PLANNING BOARD

Project Name:	Subdivision Review to Legalize 4 Units	Project ID:	PL-000023-2018
Address:	44 Pleasant Street	CBL:	040 B004001
Applicant:	44 Pleasant St. LLC		
Planner:	Christian Roadman

44 Pleasant Street
Legalization of 4 Existing Residential Units
Level III Site Plan and Subdivision Review
23-2018
Applicant: Justin Tourigny, 44 Pleasant St LLC

1 SITE PLAN NO OFF-STREET PARKING - EXISTING OR PROPOSED  
 SCALE: N.T.S.

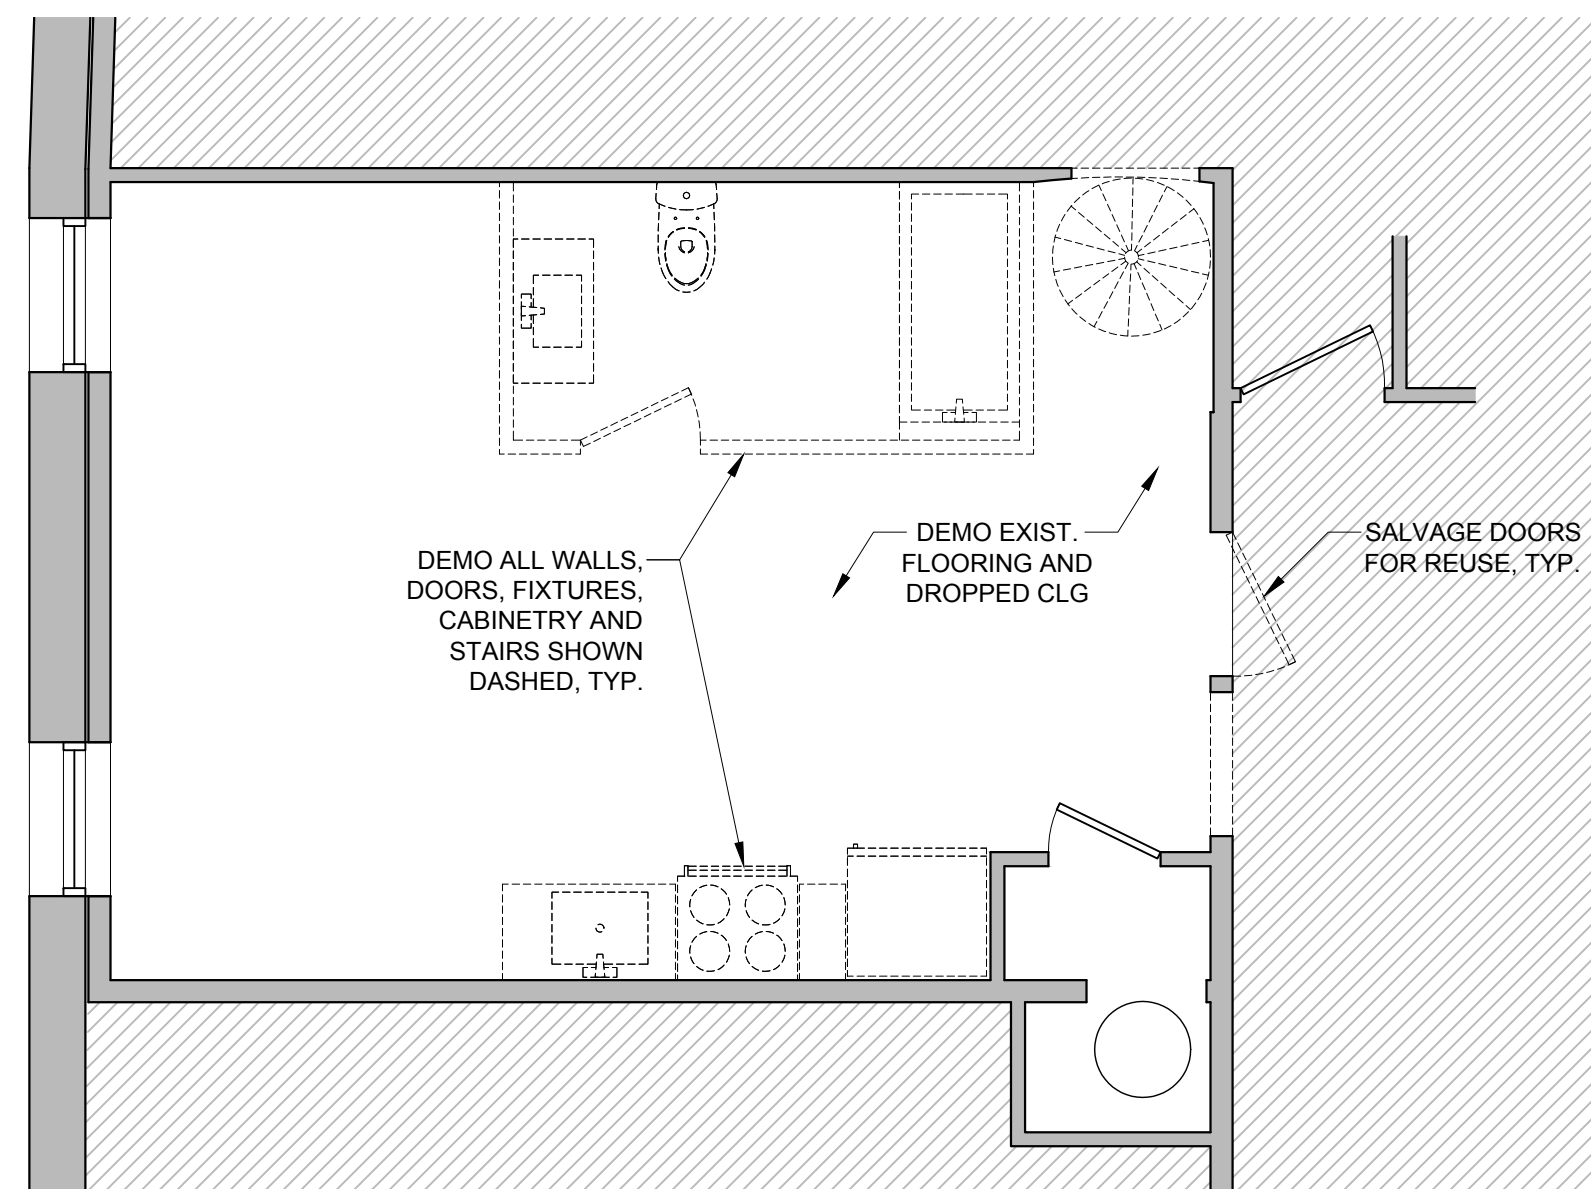
In their application, the applicants indicated an intention to install 10 bicycle parking spaces. Without a site plan, it is unclear where these spaces are intended. Staff seeks further clarity on this point from the applicant team.

Utility work in the street and sidewalk next to the building is anticipated in order to upgrade water service and install a sprinkler system. Such work may disrupt pedestrian and traffic flow. Lauren Swett, the City’s consulting civil engineer, commented that the water service upgrade should be shown on appropriate plans with adequate consideration for sidewalk and pavement repair. She also noted that a construction management plan with consideration for the utility construction impacts to sidewalk and traffic should be provided.

1. The applicant shall submit a final site plan and construction management plan for review and approval by the Planning Authority, Department of Public Works, and Corporation Counsel.
2. The applicant shall pay into the City’s street tree fund, at a cost of \$400 per tree, to account for each of the two trees not provided per the City’s Technical Standards.
